26 November 2019

Our Reference: SYD15/01513/15
Your Ref: SSD-7388-MOD-10

**MODIFICATION 10 (SSD7388 MOD 10) – THE IMAX REDEVELOPMENT, DARLING HARBOUR
31 WHEAT STREET, SYDNEY**

**Figure 10** | Existing and Proposed Property NSW building showing encroachment of the retained building into 2.0m RMS clearance zone.

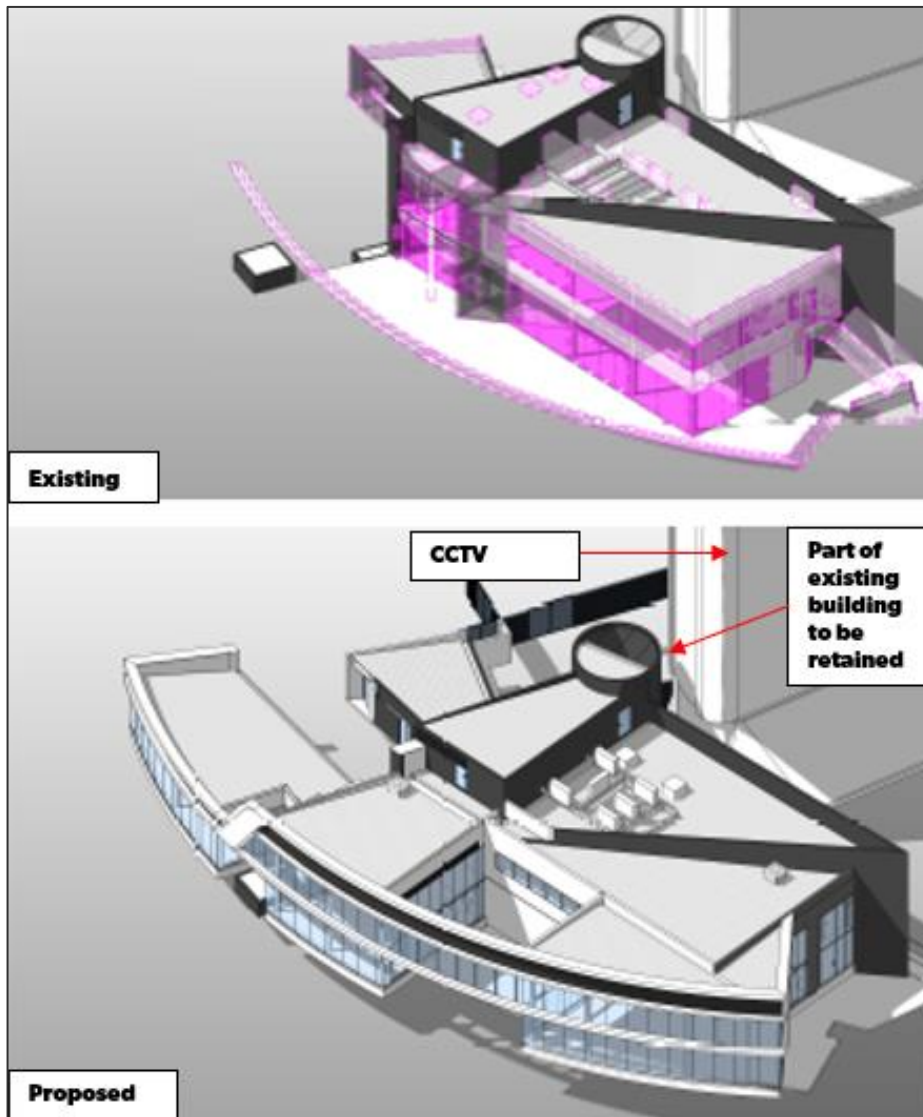
- Clearances/Encroachments: Roads and Maritime notes that the proposed modification will result in the Sydney Harbour Foreshore Authority (SHFA) building encroaching into the required 2m clearance from the Western Distributor/Cross City Tunnel infrastructure (i.e. the Cross City Tunnel ventilation stack). Contrary to the comment in the submitted modification report that *“It is noted that, in areas where the proposed SHFA building encroaches the 2m clearance area, Western Distributor infrastructure can be accessed from an alternative location. This has been informally confirmed by RMS via email correspondence”*, Roads and Maritime has not given any preliminary support for any encroachments.

Roads and Maritime have consulted with the Cross City Tunnel (CCT) Concession holder, TransurbanCCT (TCCT), as they are responsible for the operation and maintenance of the CCT infrastructure. Roads and Maritime and TCCT are not supportive of the SHFA building encroaching within the 2m clearance zone around the CCT ventilation stack due to the extension of the SHFA building to the west (refer to Figures 6, 7 and 22 in the modification report). Roads and Maritime and TCCT request that a minimum 2,000mm clearance between the ventilation stack structure and the façade be maintained as per the original approved DA and as such the submitted plans be updated to clearly demonstrate the above has been achieved.
